**PLANNING DEPARTMENT
DEVELOPMENT SERVICES DIVISION
600 2nd Street NW, Ground Floor, 87102
P.O. Box 1293, Albuquerque, NM 87103
Office (505) 924-3946**

OFFICIAL NOTIFICATION OF DECISION

Project# PR-2020-004457

SI-2021-01506 EPC SITE PLAN FINAL SIGN-OFF

| ENGINEER'S SEAL DAVID SOULE P.E. #14522 | QUIVIRA ESTATES SITE PLAN FOR BUILDING PERMIT | DRAWN BY WCWJ DATE 8-21-21 2102059-LAYOUT-9-06-20 |

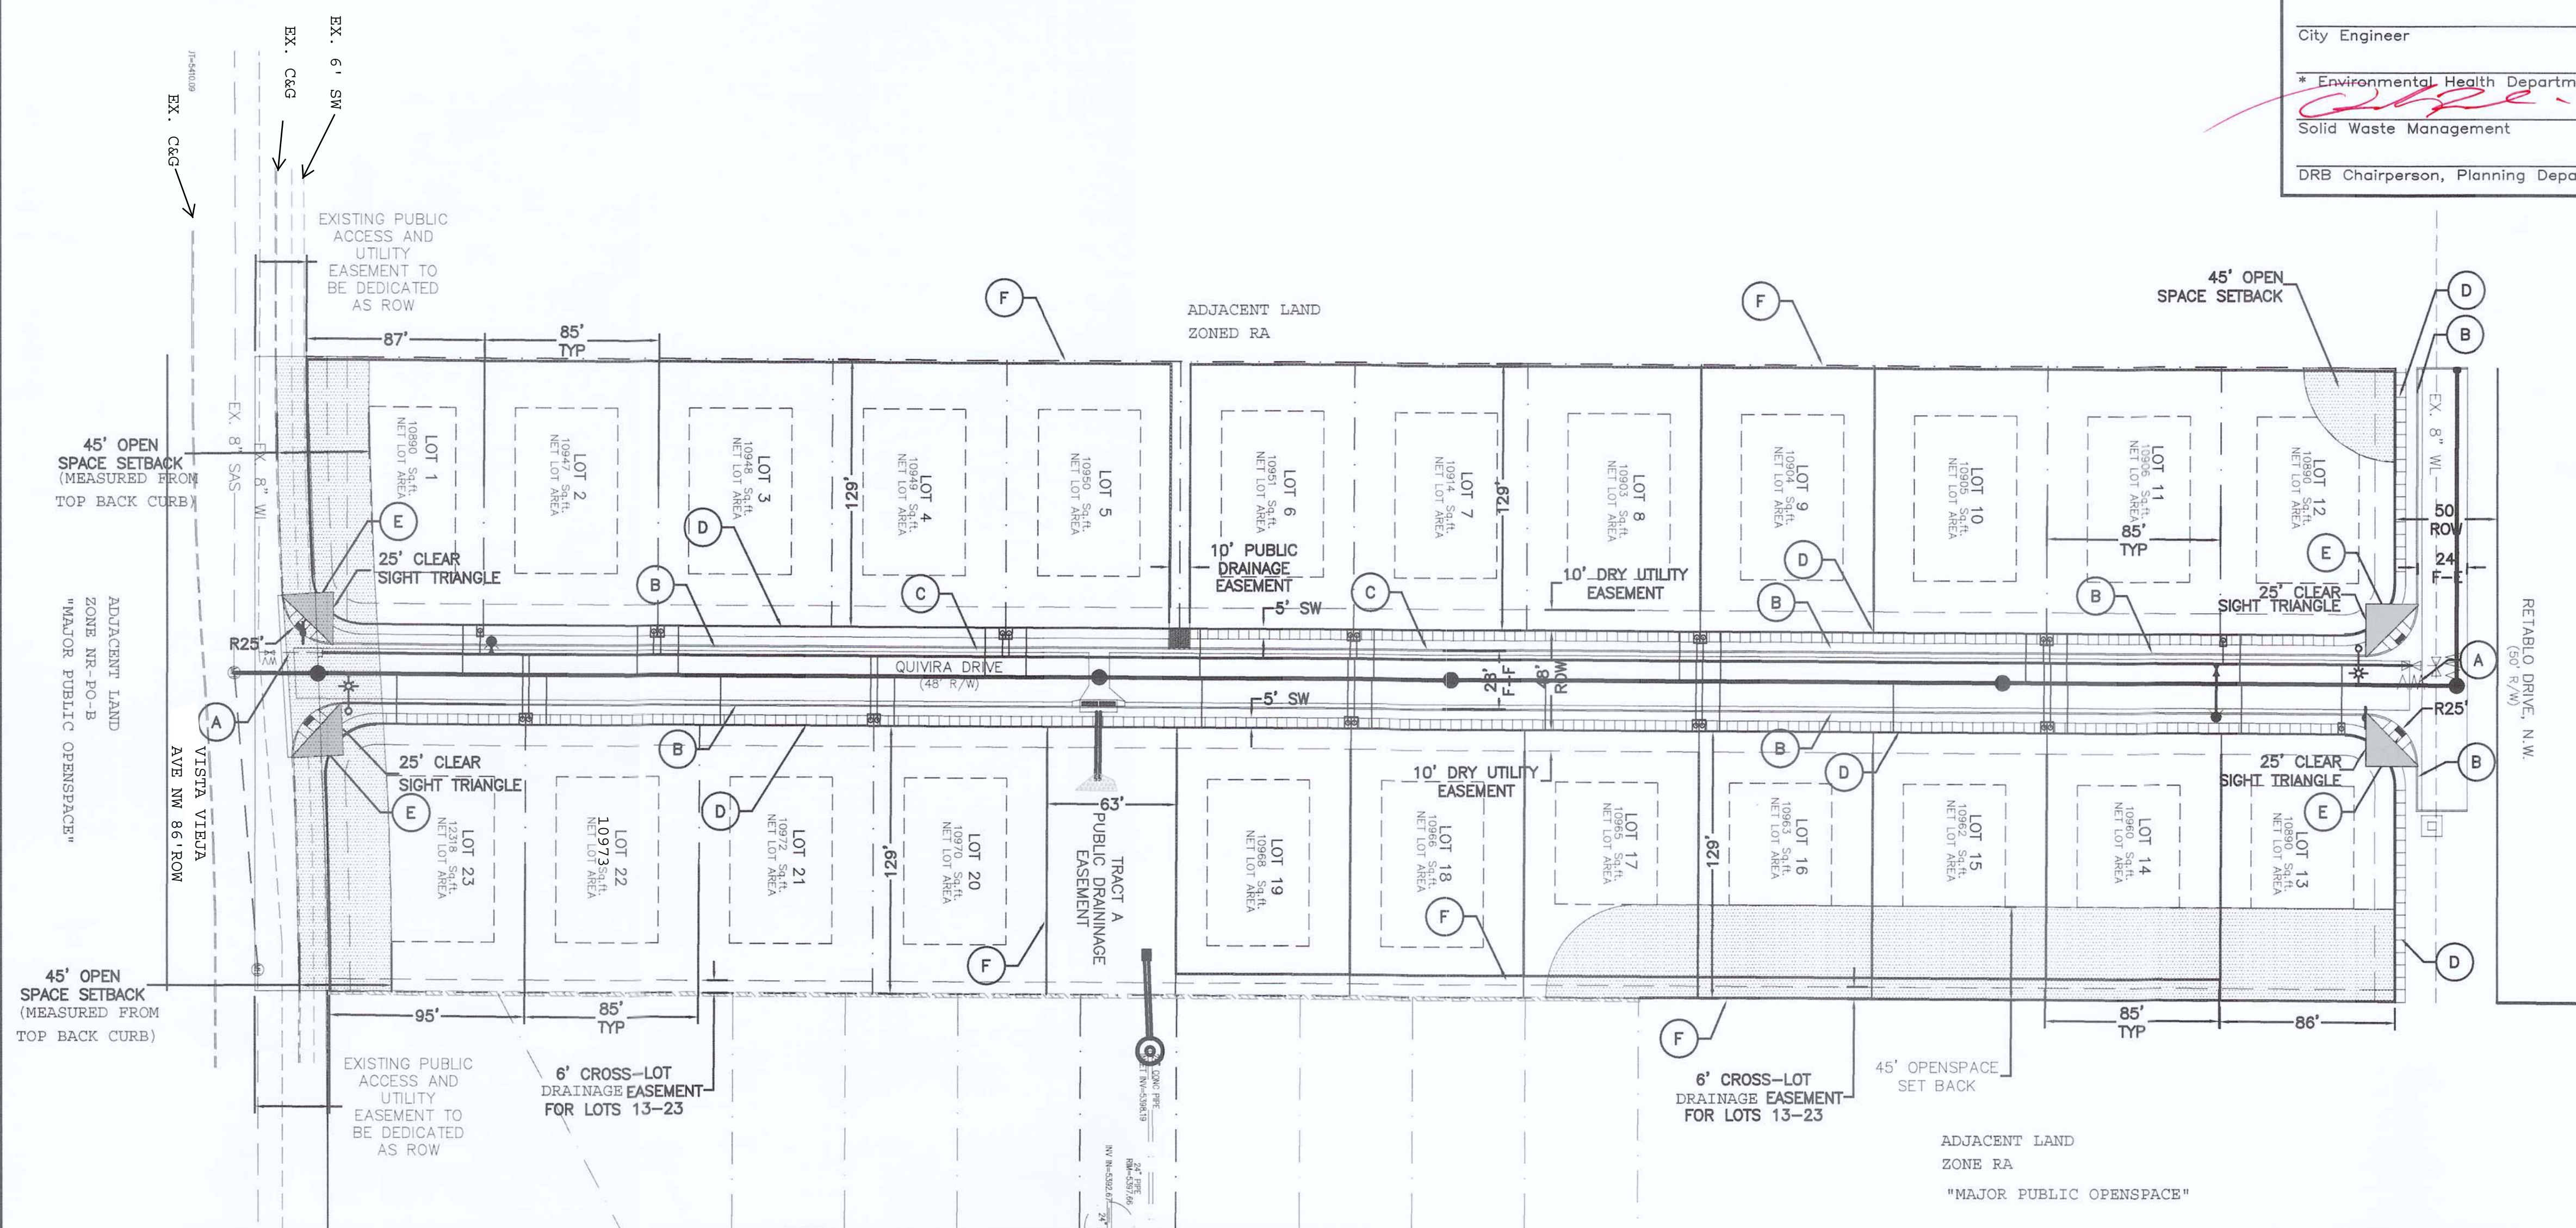
The features and improvements depicted on the Site Plan must meet the 2019 IDO requirements. Due to the adjacency of the site to MPOS, a 45-foot open space buffer and setback encroaches on portions of Lots 1, 12-17, and 23: All landscaping within the 45-foot open space buffer must be approved by the Open Space Superintendent per 5-2(K)(2)(a)(1) of the IDO, and coordination with the Open Space Division of the Parks and Recreation Department is required regarding plant selection and location prior to approval of Building Permits (on the portions of the 23 lots within the open space buffer) at the time of Building Permit submission and review. All walls adjacent to MPOS must comply with 5-7(E)(4) of the IDO.

1. Final sign-off is delegated to Parks and Recreation to clarify the note regarding the 45-foot setback at the northeast corner of the site that the area can include no structures except for view fencing.
2. Final sign-off is delegated to Planning to verify the correct IDO date on the Site Plan, for Code Enforcement to be added to the signature block, and for the project and application numbers to be indicated on the Site Plan.
3. The applicant will obtain final sign off from Parks and Recreation and Planning by November 29, 2021 or the case may be scheduled for the next DRB hearing and could be denied per the DRB Rules of Procedure.
